Application no: 22/03397/DISC

Location: Land To The South And Adj To, South Side, Steeple Aston

Lead Local Flood Authority

SECTION THROUGH 4.5m PERMEABLE BLOCK PAVED ACCESS & PERMEABLE BLOCK PAVED DRIVEWAY
Scale 1:20

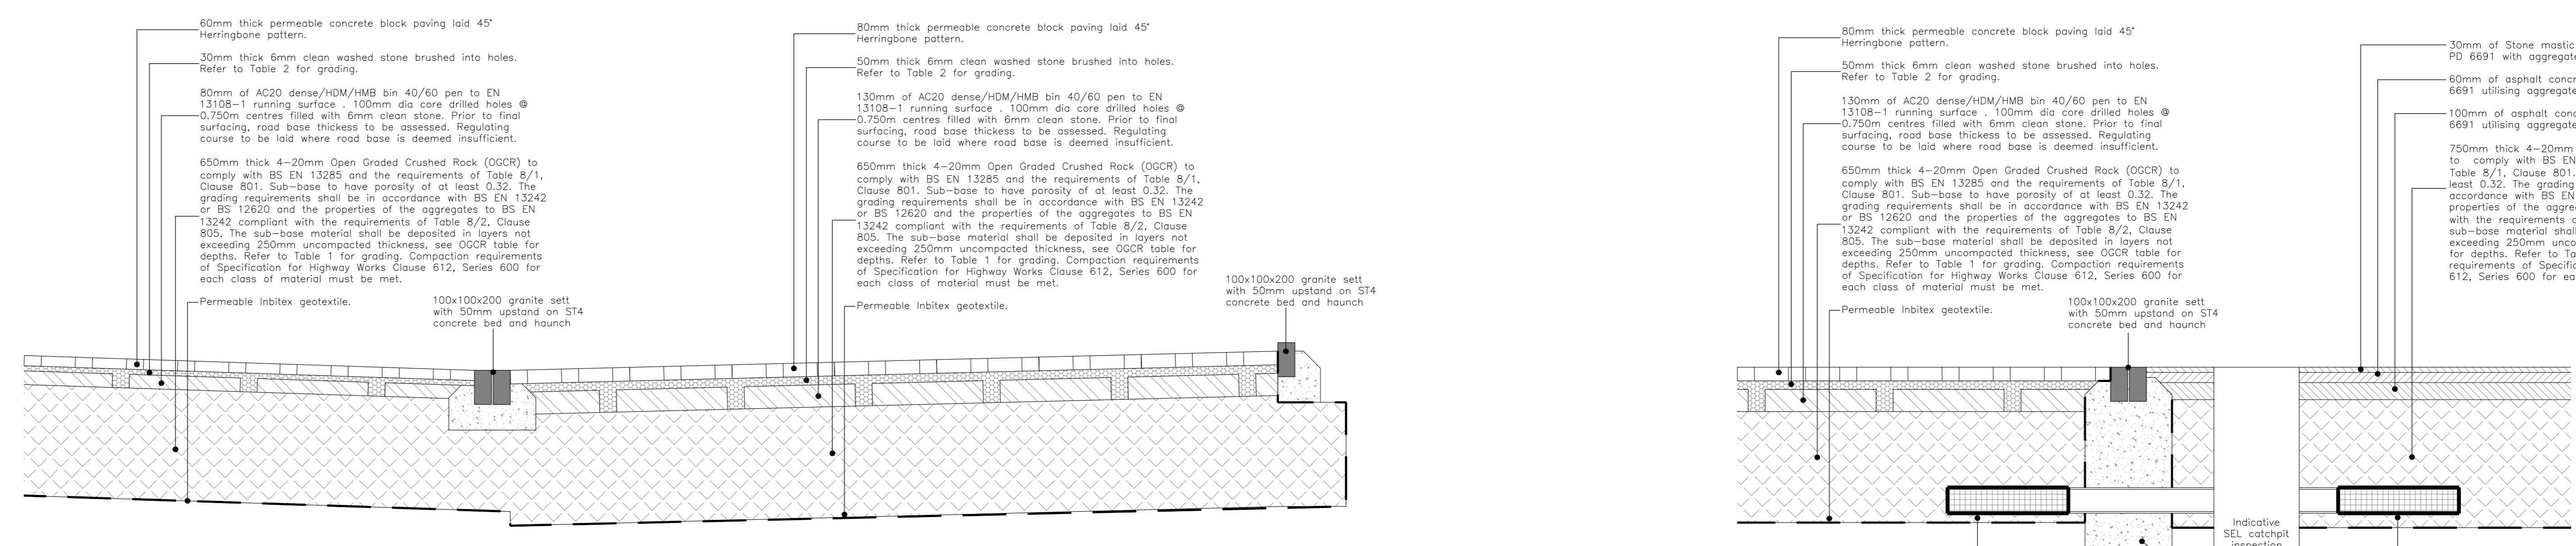
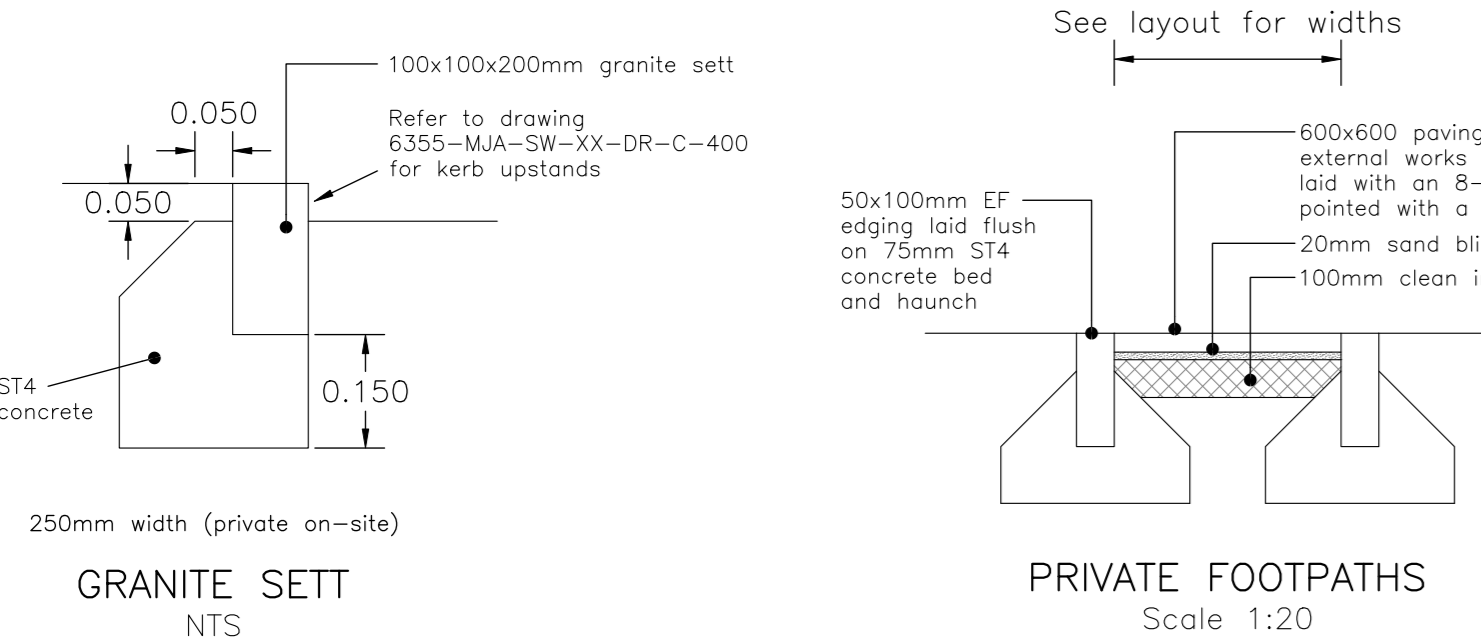
Photographs provided relates to foul drainage. This condition refers to SuDS elements and surface water infrastructure. Laying of permeable paving not provided.
